DECISION DELEGATED TO HEAD OF PLANNING

Application No: H14-0450-22 **Applicant:** P N Holdings Ltd.

Proposal: Residential Development - Erection of Dwelling (re-submission of H14-0811-21)

Location: Adj. 47 Milestone Lane Pinchbeck Spalding

PROPOSED SHADOWS

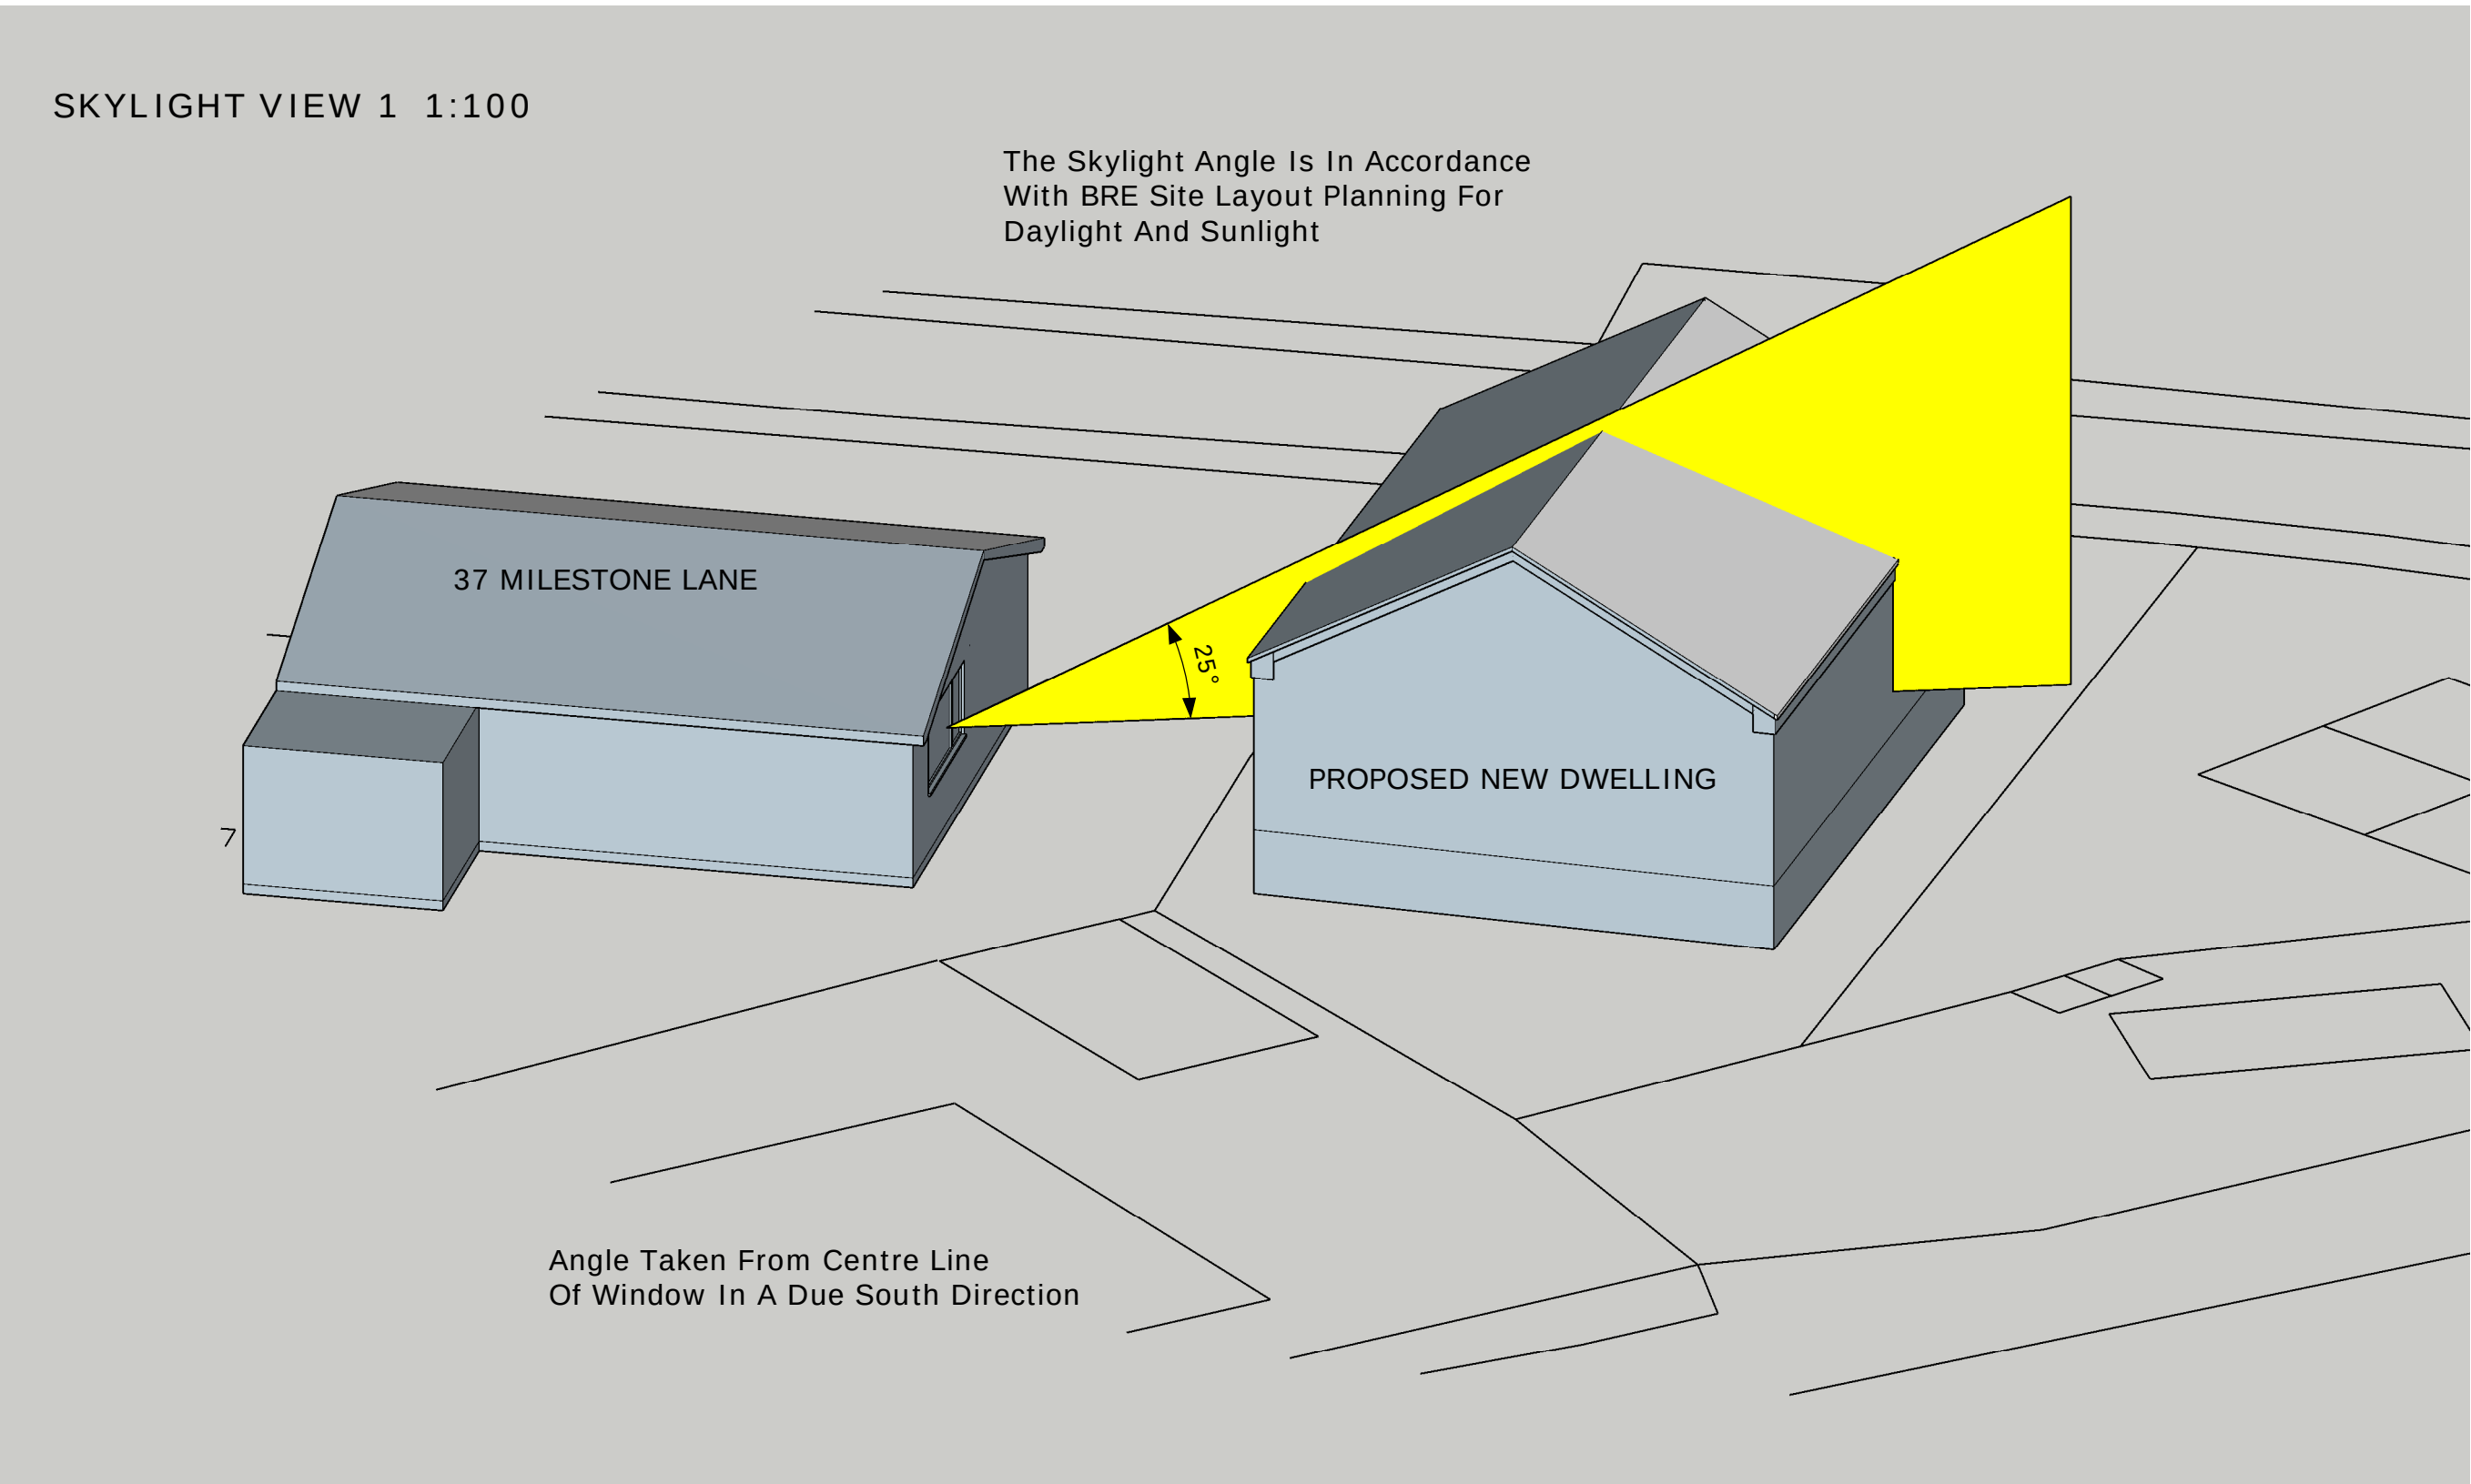
Concerns have also been raised regarding overshadowing. Given that further evidence has been provided that the proposed dwelling would not have an adverse impact on daylight/sunlight levels to the property to the north, the Local Planning Authority is unable to determine whether the impact of the proposed development on this property would be acceptable.
